Appeal Decision

Appeal Ref: APP/C3105/W/20/3263029

Brooklands, Church Street, Bodicote, Oxfordshire, OX15 4DR

- The appeal is made under section 78 of the Town and Country Planning Act 1990 against a refusal to grant planning permission.
 - The appeal is made by Mr Rowland Bratt against the decision of Cherwell District Council.
 - The application Ref 20/00841/F, dated 13 March 2020, was refused by notice dated 6 June 2020.
 - The development proposed is the erection of garage adjacent to approved dwelling and change of use of agricultural land to residential use.
-

Proposed Ground Floor Plan

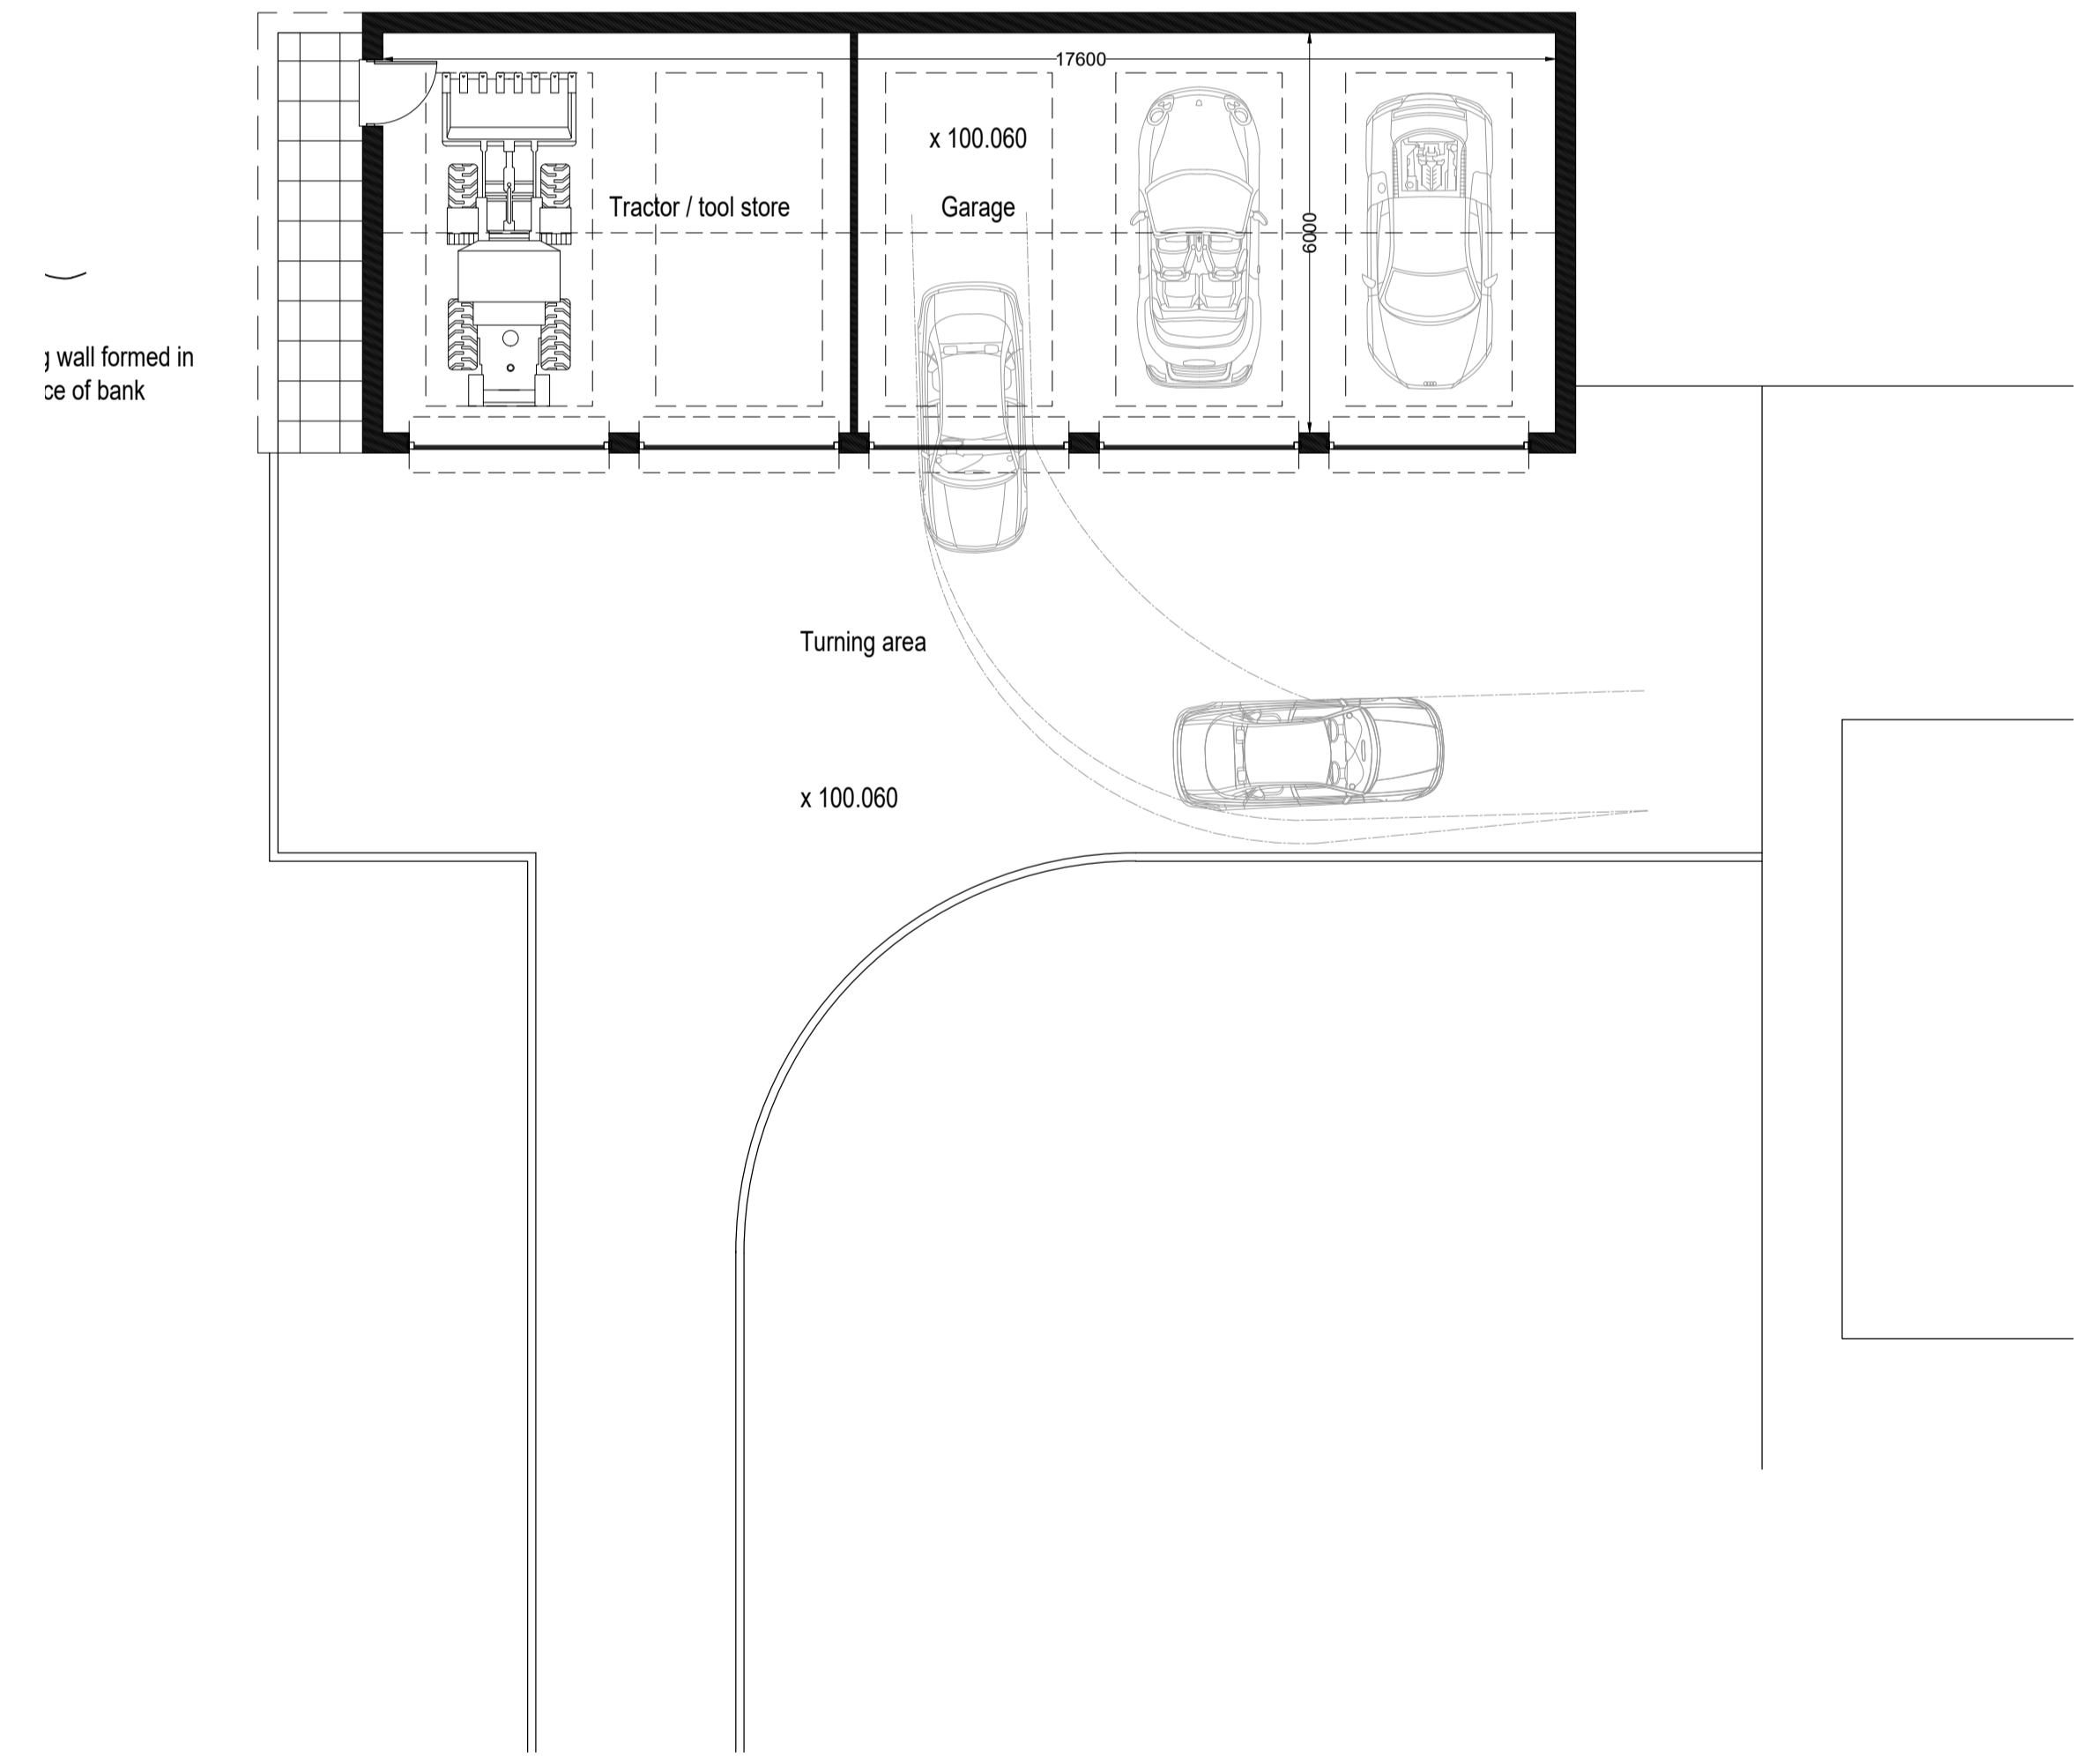
4. The appeal scheme seeks to introduce a single storey garage building to the north west of the dwelling, with a parking area provided to its front. Rather than being somewhat divorced from the dwelling, I find that it would share a close physical and visual relationship with it and for the most part would be viewed as such. The affinity between the two buildings would be reinforced by the use of matching materials. While I note the Council's concern over the commercial appearance of the proposal, given that the dwelling itself is formed from a converted building, this appearance would in my view be acceptable and would not be at odds with the character of the site and its surroundings.

5. The garage would comprise of five bays, two set aside for the storage of machinery for management of the surrounding land, and three for the parking of domestic vehicles. I note that it is somewhat larger than that which may ordinarily be associated with a dwelling, nonetheless the scale of the building would be subservient to what is a substantial dwelling. Moreover, the height of the garage would sit well below the dwellings' overall height.

6. I acknowledge that the existing structure at the site is visible from vantage points in the surrounding area; this would also be the case for the proposed garage. However, its visual presence would be mitigated by its close relationship to the dwelling, the use of the matching materials providing visual cohesion to the

appearance of the two buildings, as well as most significantly by the rising ground levels to the north of the site. It is against this increase in ground level which the development would be seen from the majority of views. From views from the east the converted building would screen the majority of views and from the south, from elevated ground, the garage would nestle into the ground levels of the site and the surrounding land. In this context, the building would appear as a subservient element, one which assimilates with the appearance of, and would appear significantly less prominent than, the main dwelling.

8. In isolation therefore, I find that the appeal scheme would not be harmful. However, I am particularly conscious that since the time of the refusal of the planning application, a further scheme has been submitted and has been granted planning permission by the Council for the erection of the same garage in a different position, i.e. further to the south in front of the dwelling itself. This is a matter to which I must have regard. The two garages would occupy discrete positions within the site and thus could both be constructed independently. This would lead to an increased quantum of built development at the site and result in visual clutter, harming the rural character of the location. I am conscious that the appellant highlights a willingness for the subsequently granted planning permission to be revoked. However, a planning permission can only be revoked following a specific process, which I am not aware has been undertaken. Furthermore, I am not satisfied that a planning condition could be used to prevent implementation of the already approved scheme.

9. In this case therefore, given that the appeal scheme could lead to the potential for the harmful proliferation of buildings at the site, I must find that it would result in a detrimental effect on the character and appearance of the area. Thus, it conflicts with saved policy C28 of the Cherwell Local Plan (adopted November 1996) and policies ESD13 and ESD15 of the Cherwell Local Plan – Part 1 (adopted 20 July 2015). Together, and amongst other things, these policies seek to ensure development is sympathetic to the rural context, that development respects landscape character and that proposals reinforce local distinctiveness.
